CITY OF ALBUQUERQUE PUBLIC WORKS DEPARTMENT	
TITLE: ANDERSON HEIGHTS - UNIT 4 GRADING & DRAINAGE PLAN	
DESIGN REVIEW COMMITTEE	CITY ENGINEER APPROVAL
LAST DESIGN UPDATE	MO./DAY/YR.
CITY PROJECT NO.	ZONE MAP NO.
SHEET 3 OF 4

**Re: Anderson Heights Unit 4 Grading and Drainage Plan
Revised Engineers stamp date 4-1-15 (N08 / D006F)
With revisions dates 4-22-15 (sht 3) and 4-14-15 (sht 4)**

RE: **Anderson Height Unit 4 (File: N08D006F)**
Drainage Report, Engineer's Stamp Date 2-12-2015
Grading & Drainage Plan Engineer's Stamp Date 5-1-2015

TITLE: **ANDERSON HEIGHTS - UNIT 4
GRADING & DRAINAGE PLAN**

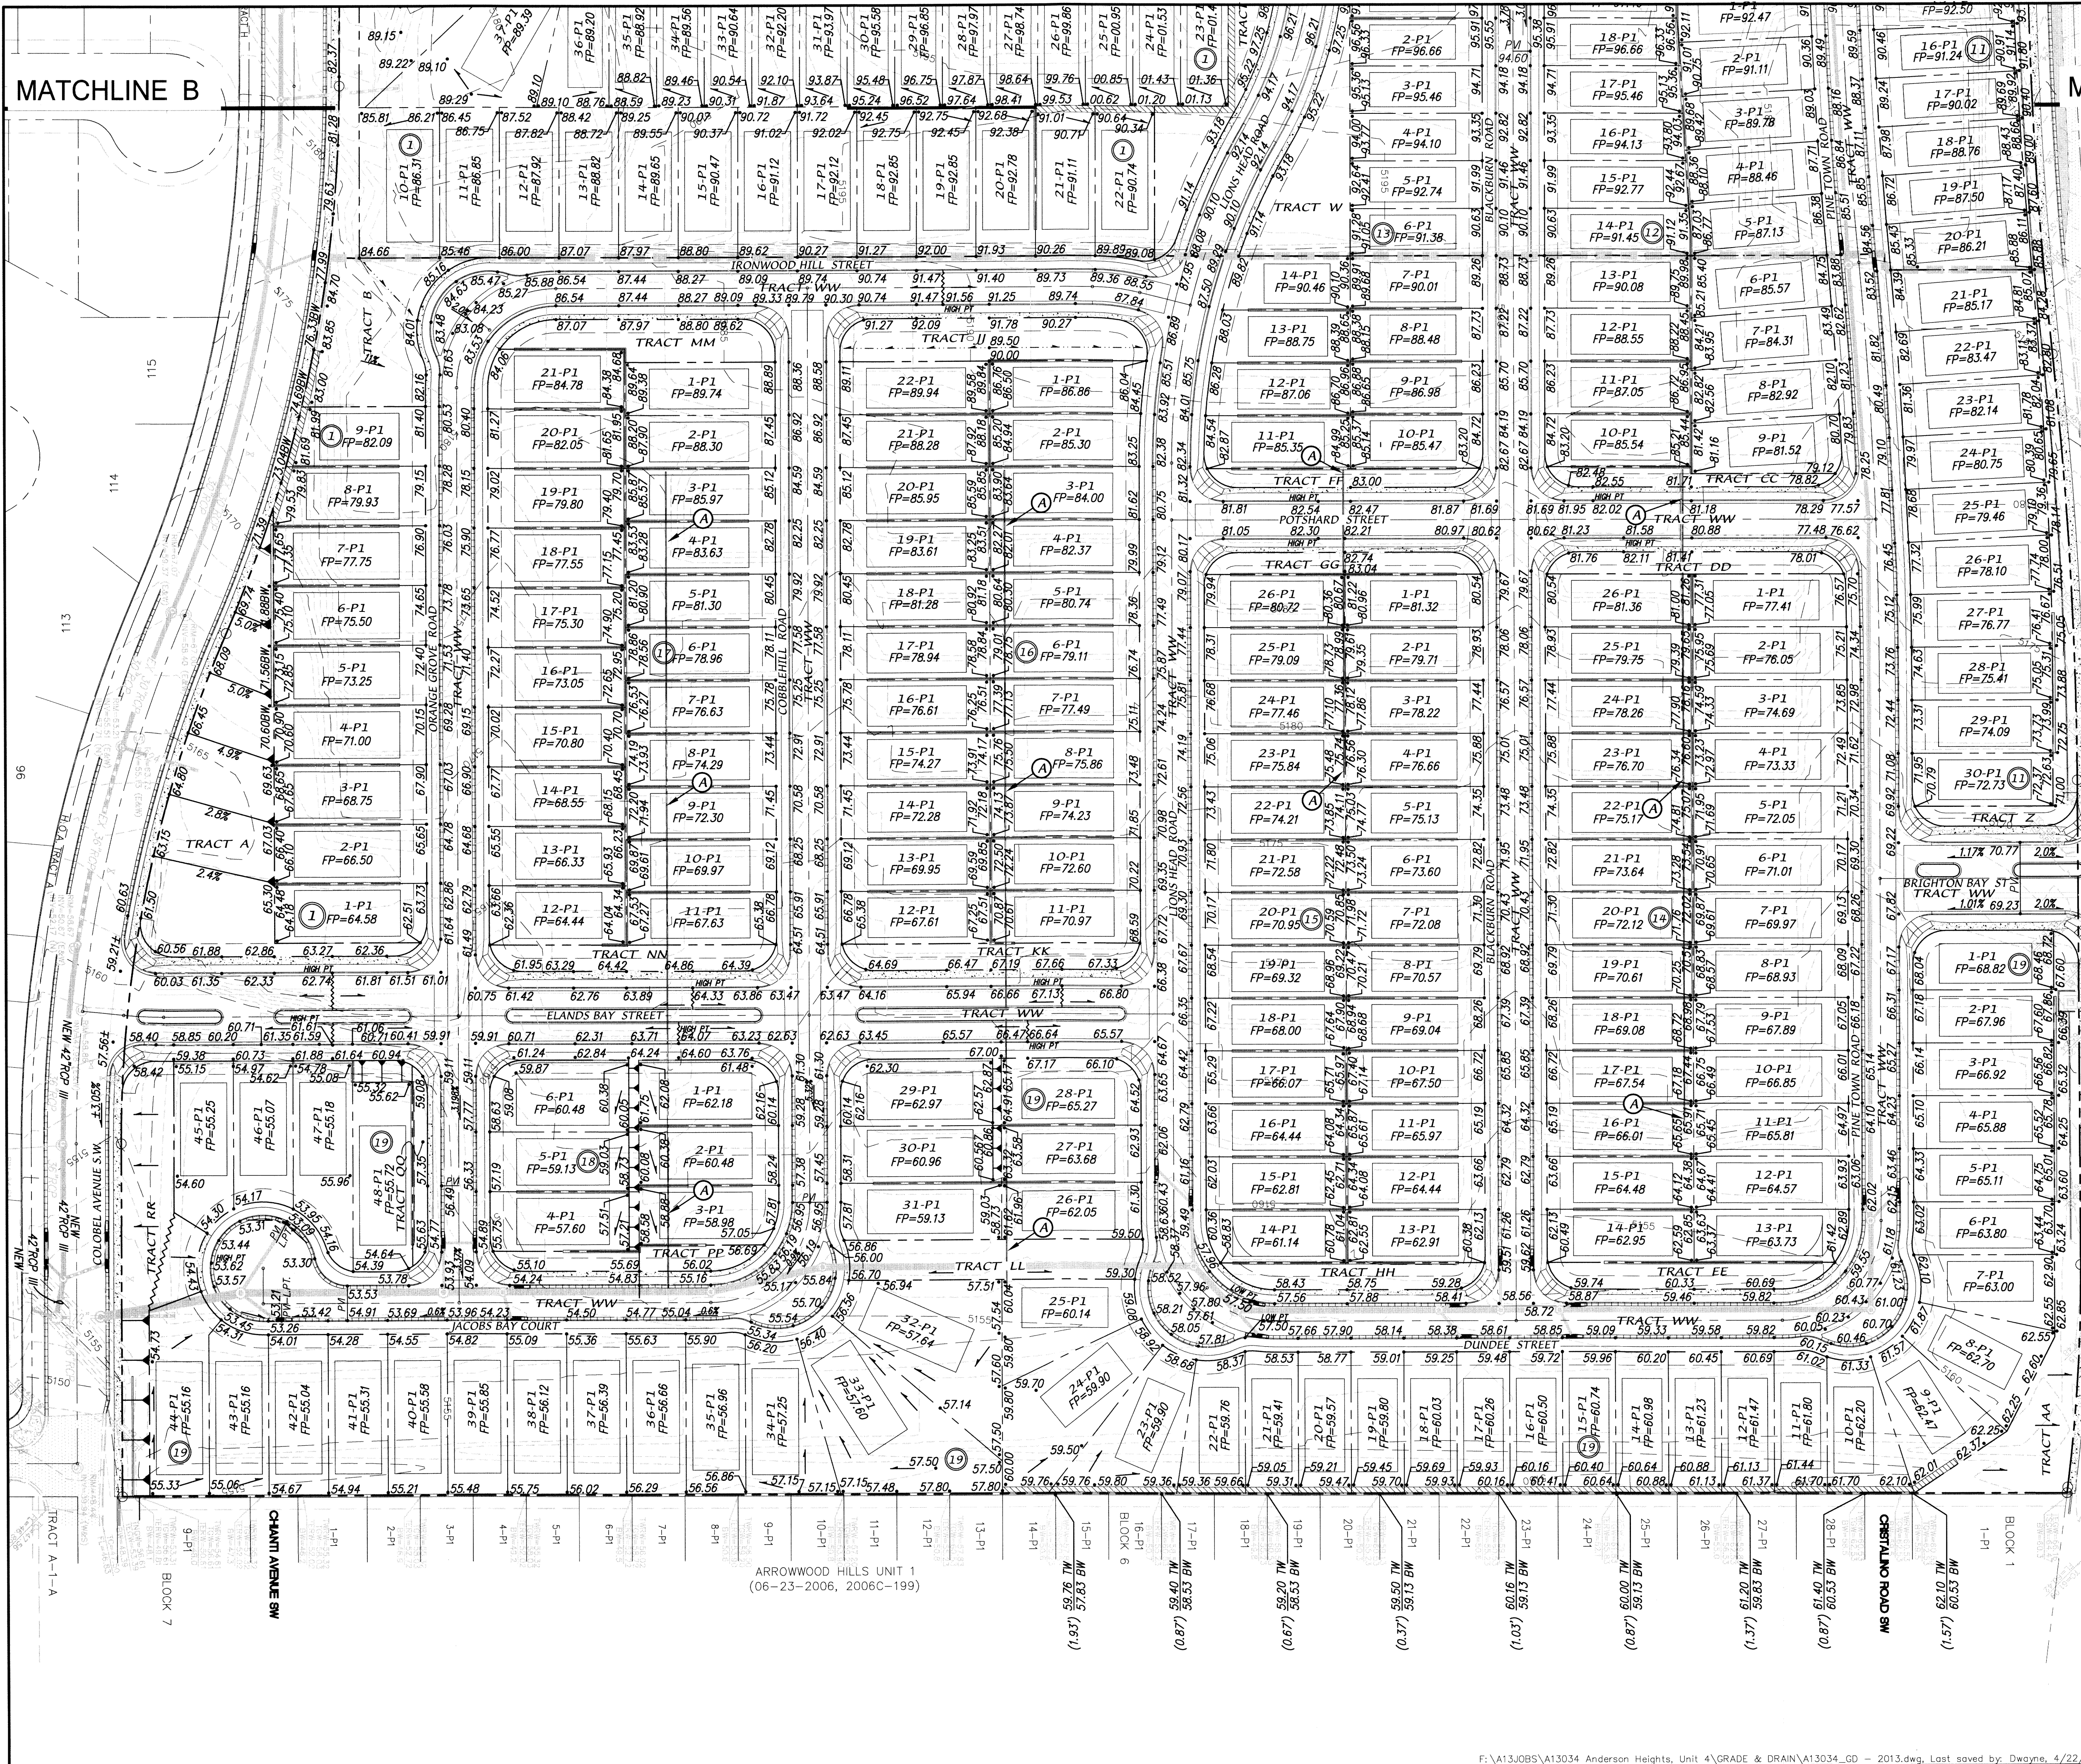
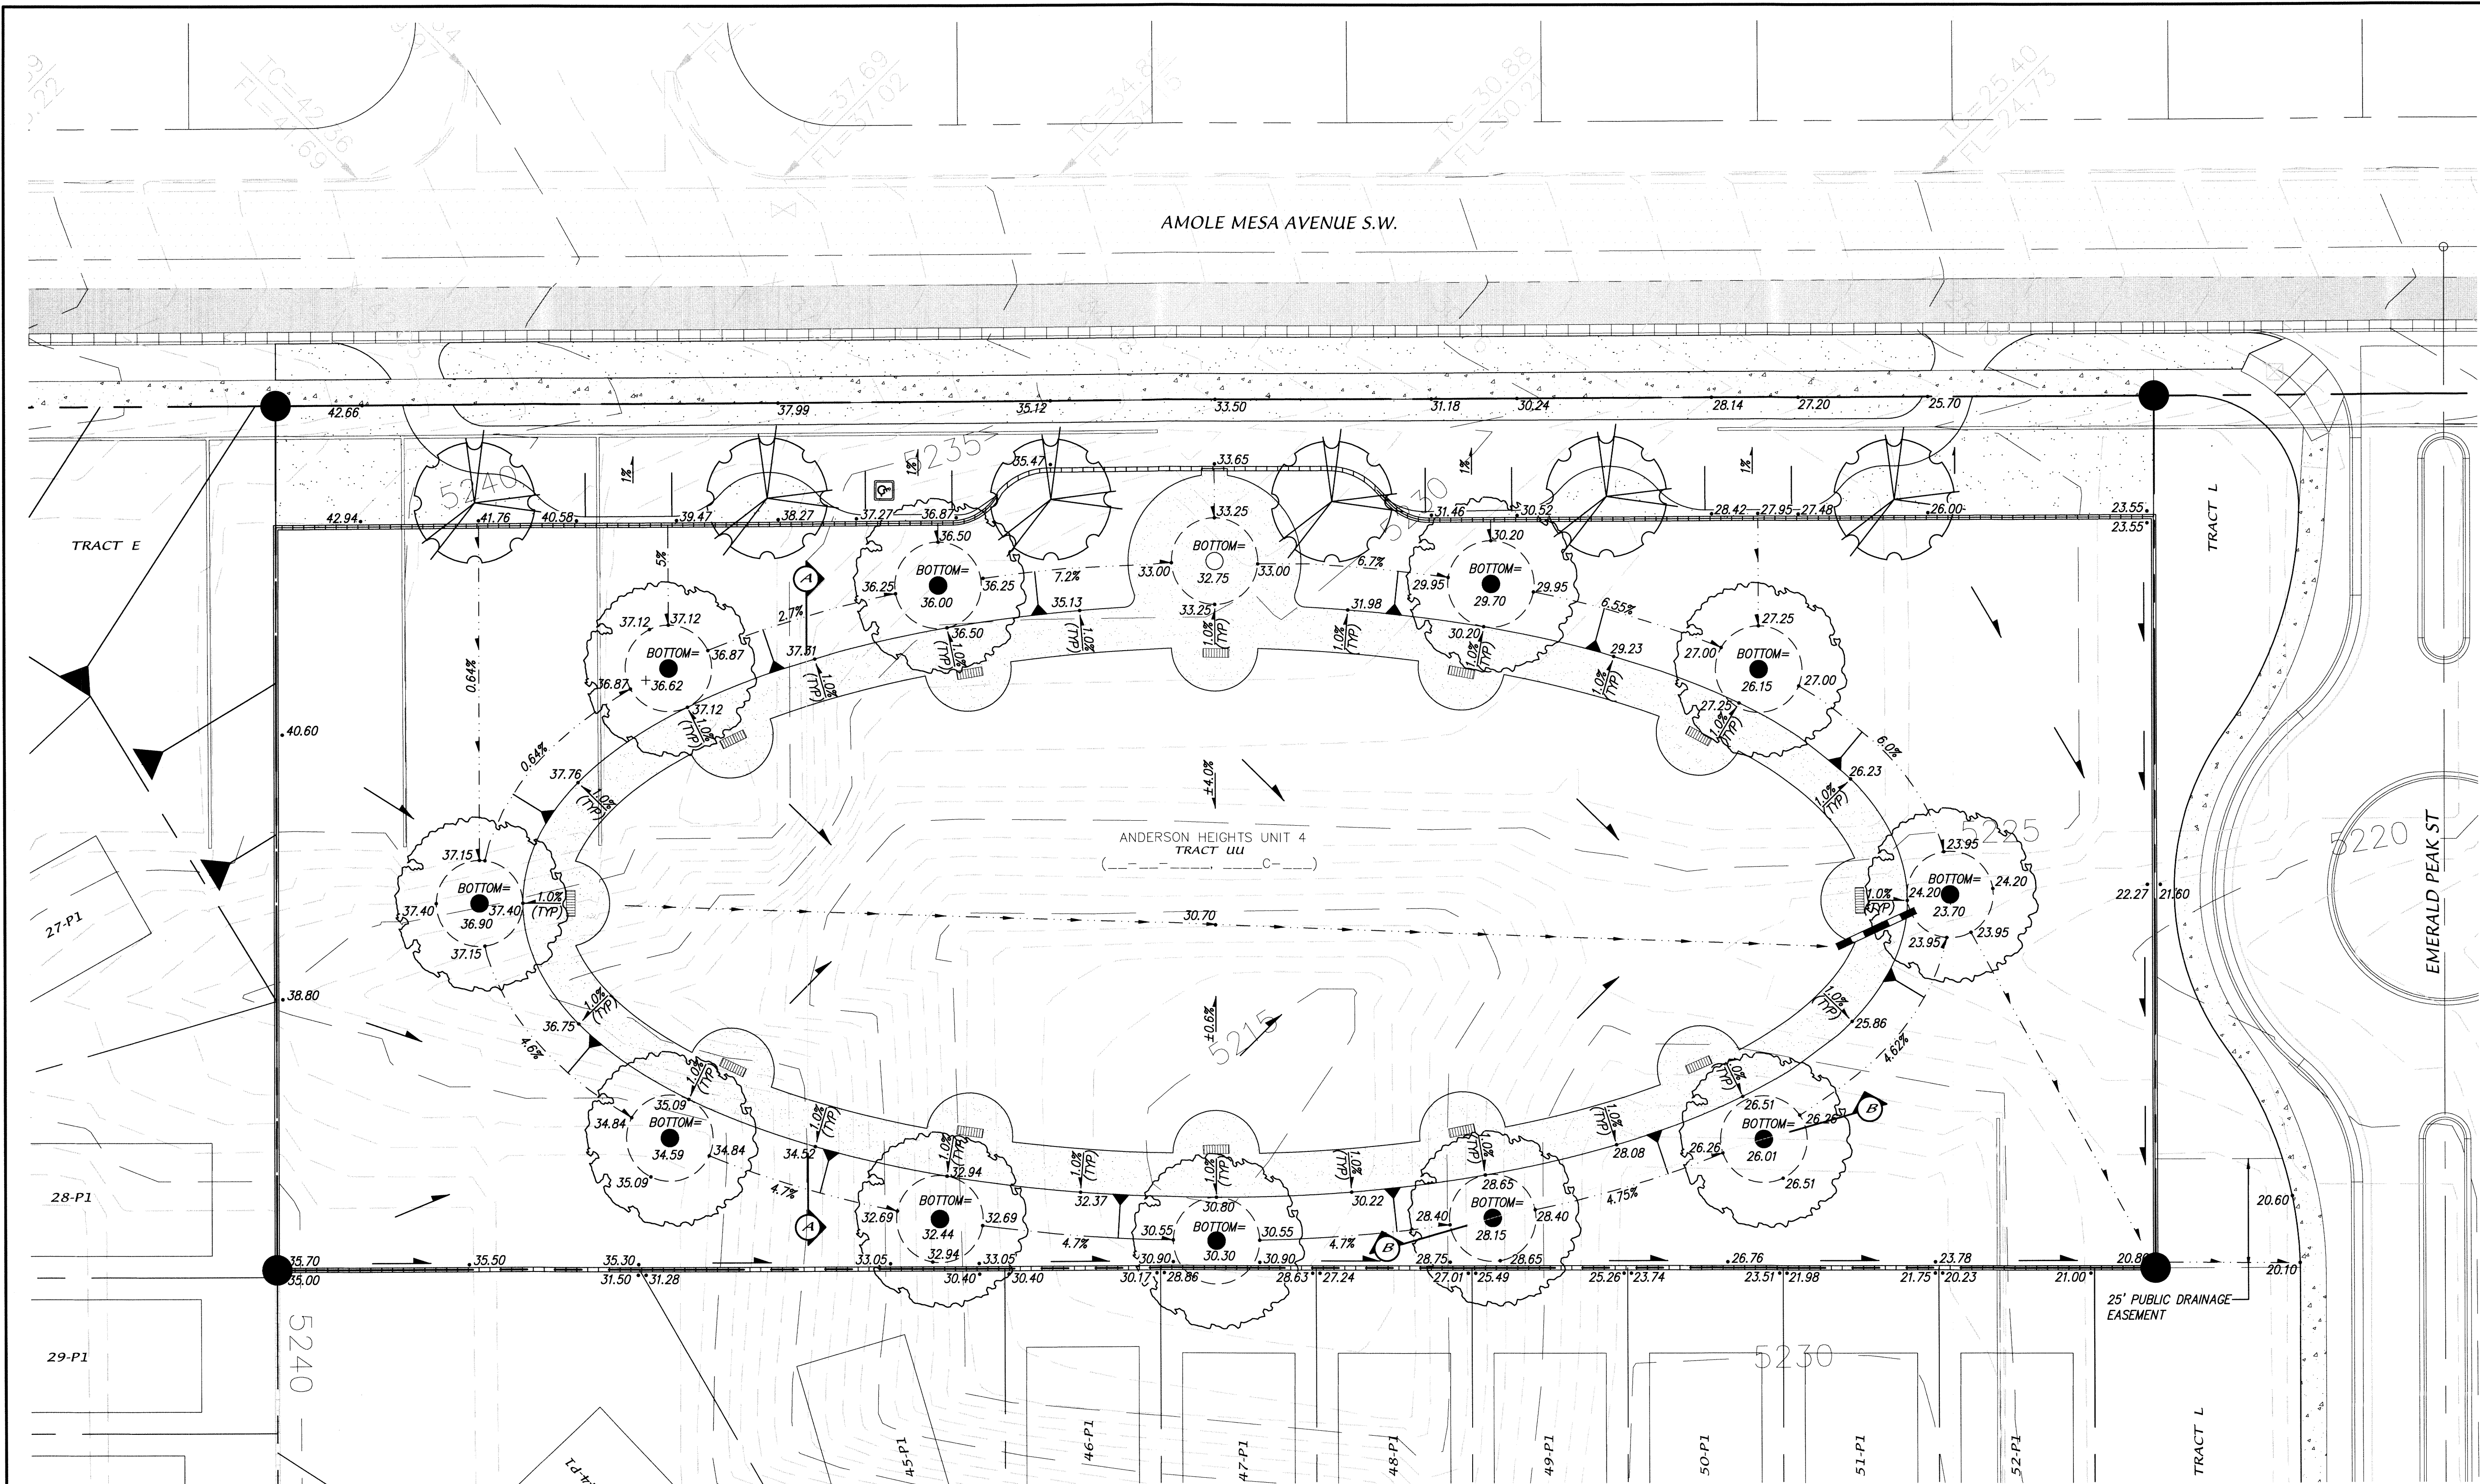
In response to comments received at DRB from Open Space and from conversations regarding the retaining walls along the east property boundary:

1. The Memorial Park was revised to add additional detail to the plan. The concept is unchanged just more detail.
2. The grades along the east property line were revisited. I have lowered the grades in Jacob Bay Court as much as possible while still maintaining minimum required cover over the storm drain. I have graded the backyards so that the grades are equal to or below the TWRW (top of west retaining wall).
3. The grades in Dundee Street remain unchanged. There is already minimum cover over the storm drain in this street. Consequently, the back yard grades, along Dundee Street, are higher than the TWRW. I have indicated proposed retaining walls along this area as shown on the revised plan. The maximum additional retainage is 2.0 feet.
